1 Bradley Court
Thornley road
Chaigley
Clitheroe
BB7 3LY

Planning Application 3/2020/0344

3 Proposed Rear (west) Elevation  
1 : 100

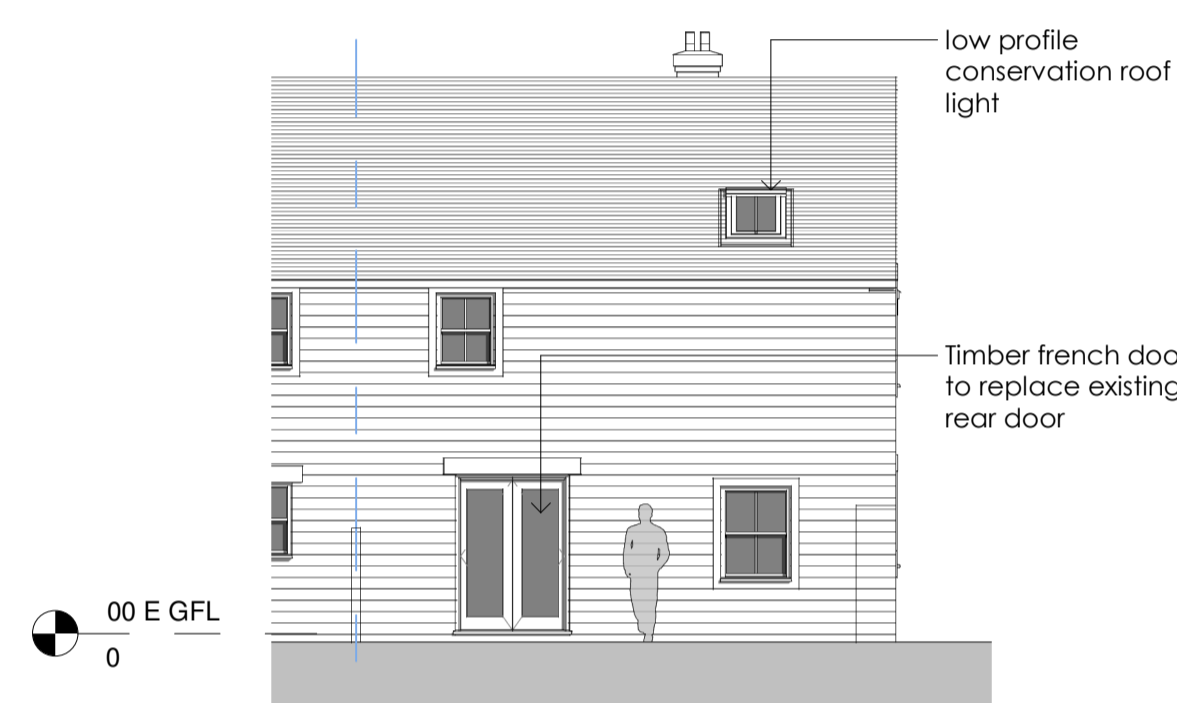
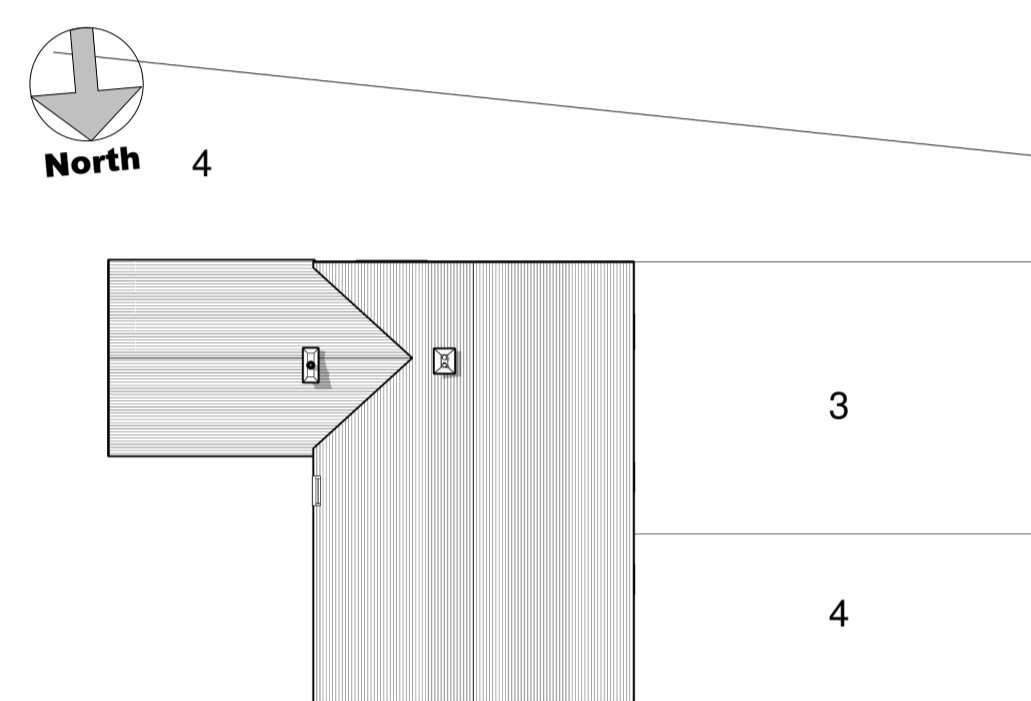
1. Proposed Rear (west) elevation. A, If the colour of the frame of the conservation roof light matches the colour of the slate roof, it would be appreciated. B, The planned timber French doors are twice the width of the existing door. If planning accept this proposal in effect it gives a green light for the adjoining properties, 4,5,and 6 to apply for the same. Could planning consider the original consents given at the time of the conversion approximately 25years ago.
2. Proposed Side (south) elevation. A, Regarding the upstairs double window to match existing. If the planning committee see fit to agree with this application, could there be a comment that great care is taken so as not to disturb the existing ceramic round pipes that form part of the original barn. These pipes have become a sanctuary for House Sparrows. These birds are

2cont. B. The lower double windows gives some concern. I enclose photos of the stonework. Planning will see where the original barn was extended. The cornerstones of the original building can be clearly seen. This feature could be lost or compromised should this fenestration be accepted. There is a delightful small window light in the wall. If the proposed window were redesigned to be a replica in a modern design of this small window, (that is to say a window nearly as tall as the ones proposed but much narrower single frame). It could be a feature.
